**WEST SUSSEX COUNTY COUNCIL
STRATEGIC PLANNING CONSULTATION**

SUBJECT: R/202/15/HH-New vehicular access.

72, Worthing Road, Rustington, West Sussex, BN16 3LL

Proposed Crossover at 72 Worthing Road

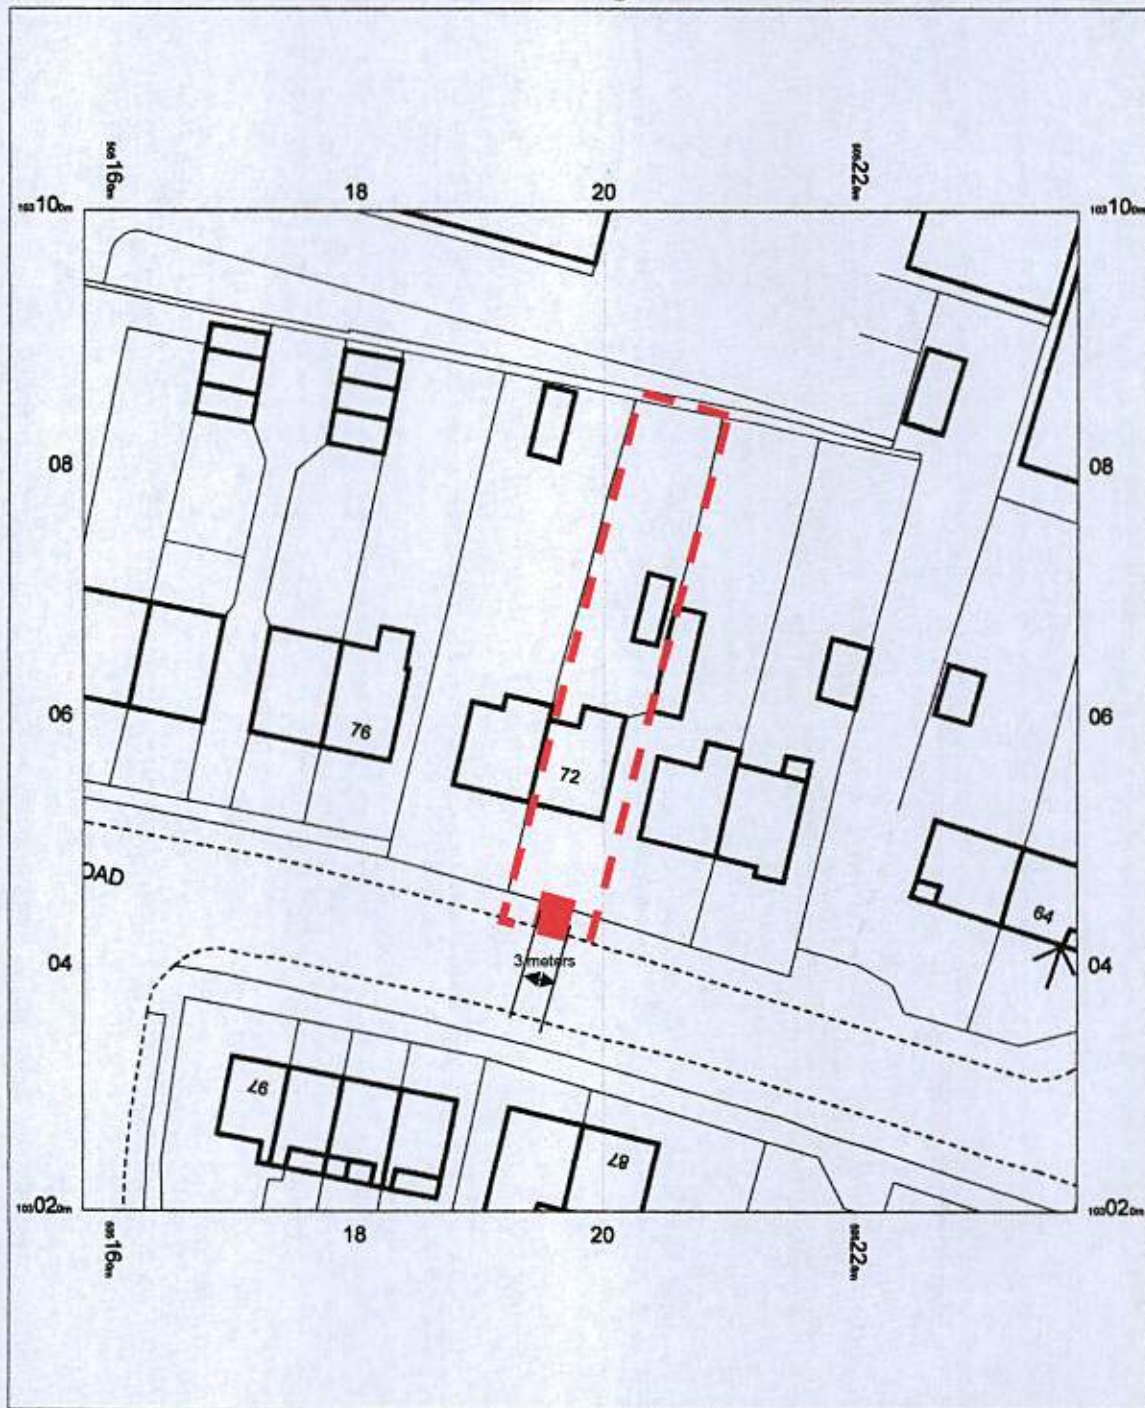
No concerns would be raised to this proposed crossover. There are a number of other properties in close proximity which have similar access arrangements. The new access should be constructed in crossover construction in accordance with the specification obtained from

WSCC. I would also seek that the driveway is constructed in a bound material and not left as a loose material that may then be carried onto the public highway.

If the LPA are minded to approve this application a condition securing the new access should be included.
